Your Ref: 100659898-001
Our Ref: 24/00315/FULL

Application No: 24/00315/FULL
Proposal: Change of use from ancillary domestic store (Class 9) to short-term holiday let (Sui Generis) and replacement roof and formation of decking
Address: Forgehead Smithy Road Balmullo St Andrews Fife

LOCATION PLAN

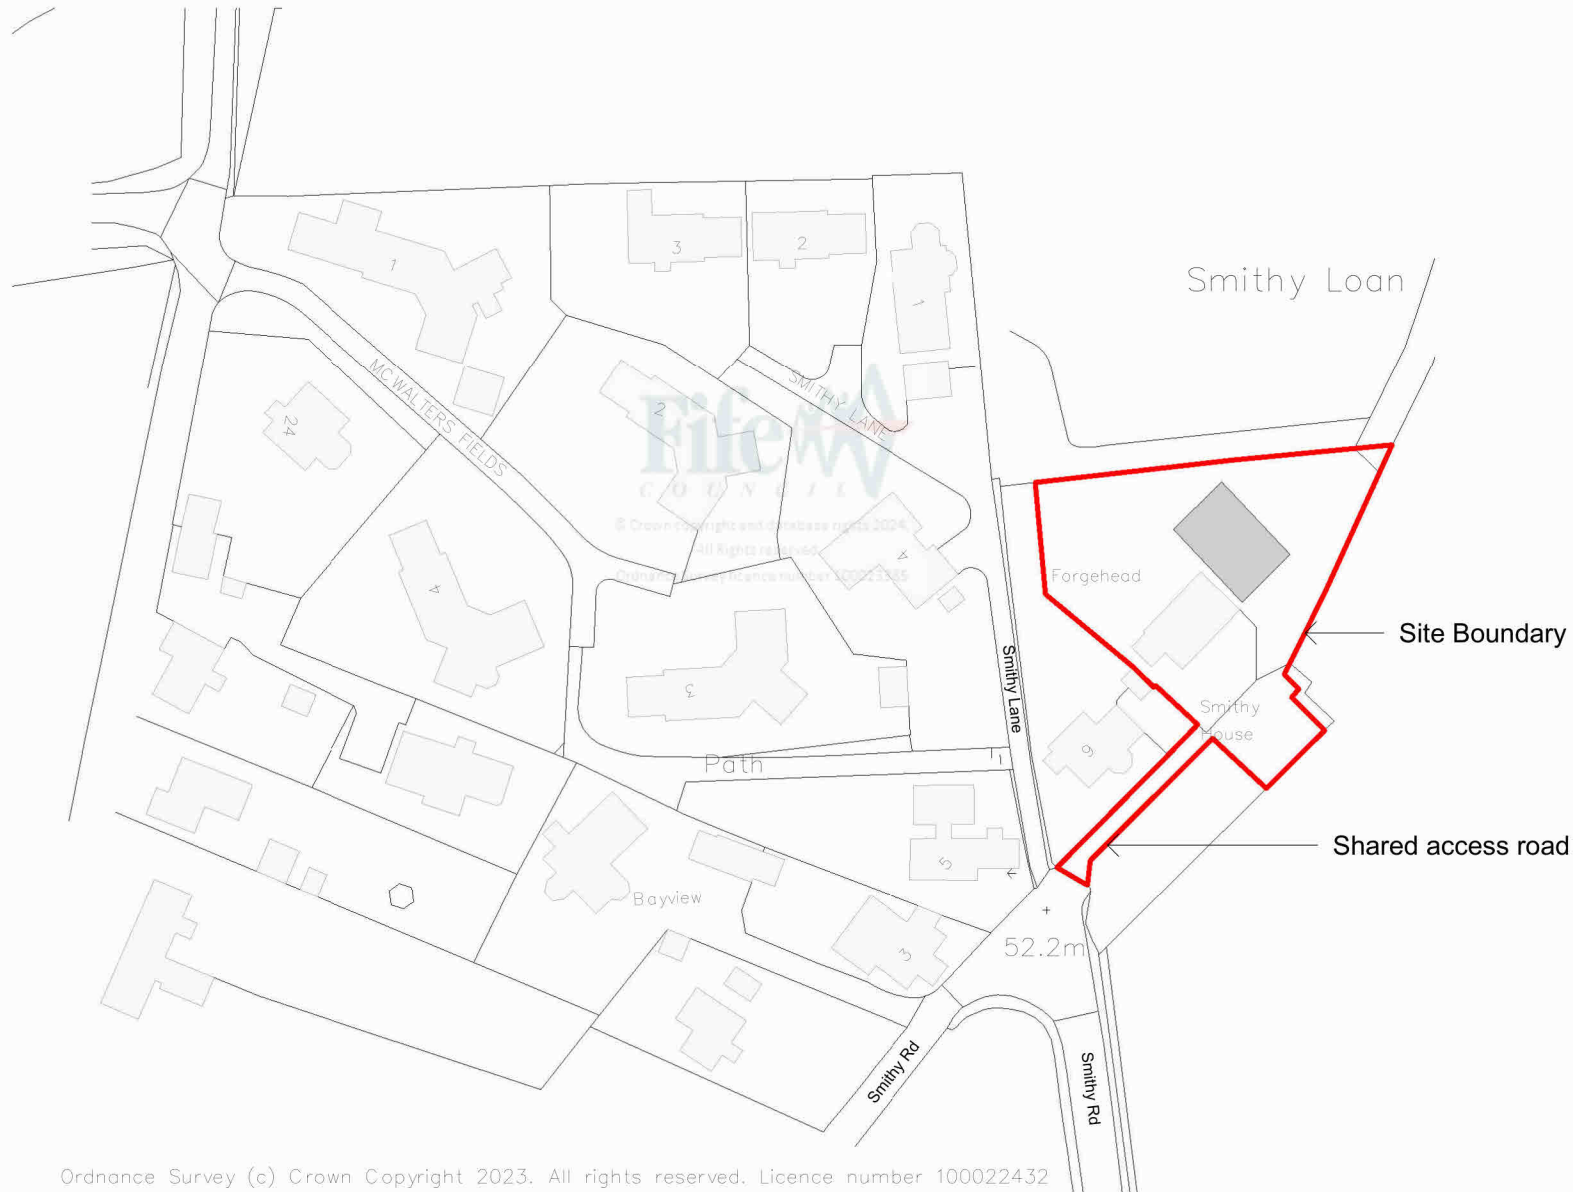
1. You have not submitted a valid location plan as there are multiple red-lines. Please include the application site and access within a single red-line.
2. Although this is not part of validation, we should highlight that the Council is required to advertise planning proposals where there are no premises situated on neighbouring land. The cost of this is then charged to the applicant under the Town and Country Planning (Charges for Publication of Notices (Scotland) Regulations 2009. As there are no premises situated on the neighbouring land in respect of the above planning application it requires to be advertised. The charge for this is £162.00. The application cannot be determined until this charge is paid.
